Application for a non-material amendment following a grant of planning permission.

TWO STOREY SIDE AND REAR EXTENSION, SINGLE STOREY FRONT PORCH EXTENSION AND NEW ORIEL WINDOW TO GROUND FLOOR FRONT
APPLICATION REF : R/90/13/
DATE OF DECISION : 28th MAY 2013

R/90/13

DRG NO 1304/F02AA

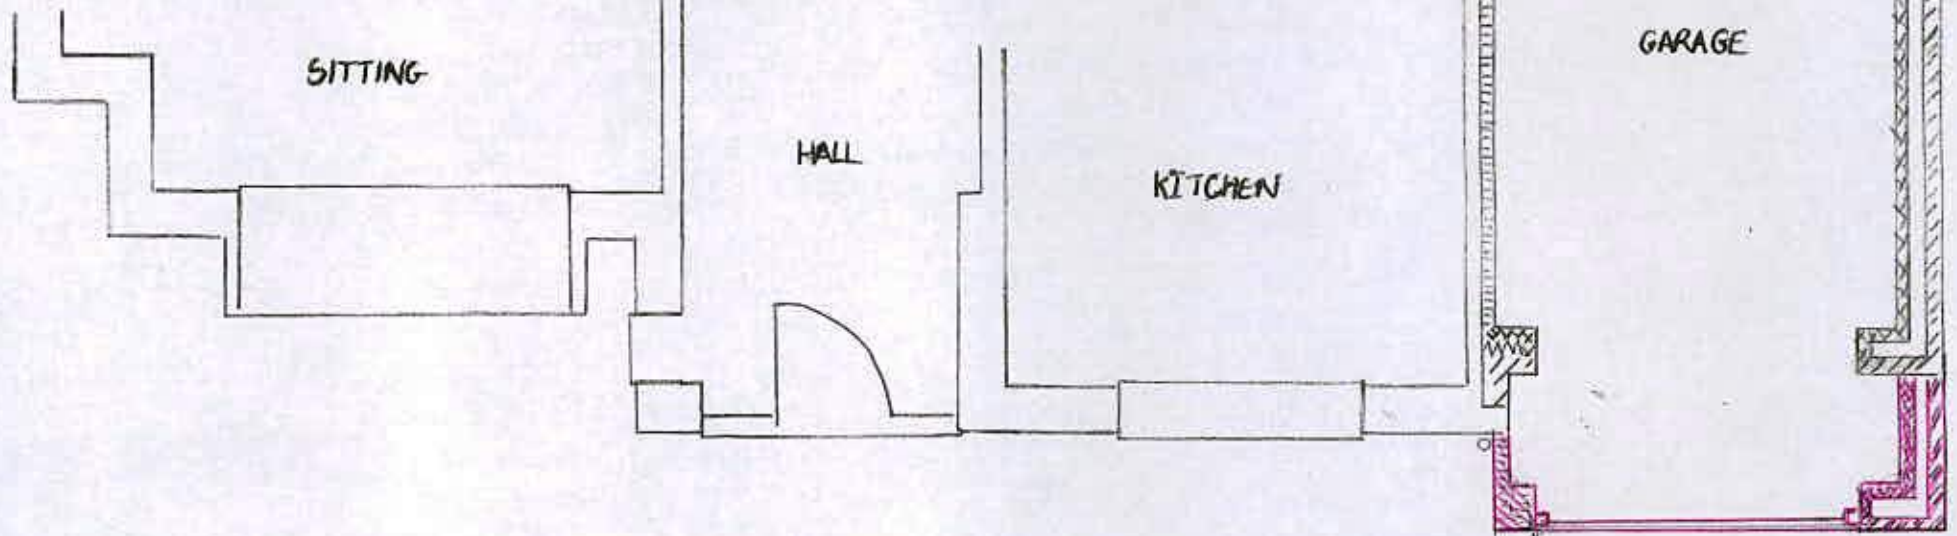
A 1 METRE EXTENSION FORWARD FROM THE CURRENT GARAGE,
A GABLE END ROOF STRUCTURE, COMPLEMENTING THE EXISTING PORCH ROOF.
ROOF TILES TO MATCH EXISTING.

VERTICAL TILE HANGING ON FRONT GABLE TO MATCH EXISTING.

RIGHT HAND SIDE : CONTINUE AS CAVITY, 2 1/2 BRICKS WIDE, 550mm.

LEFT HAND SIDE : SINGLE SKIN WALL, WITH 1 BRICK WIDE PIER, 215mm.
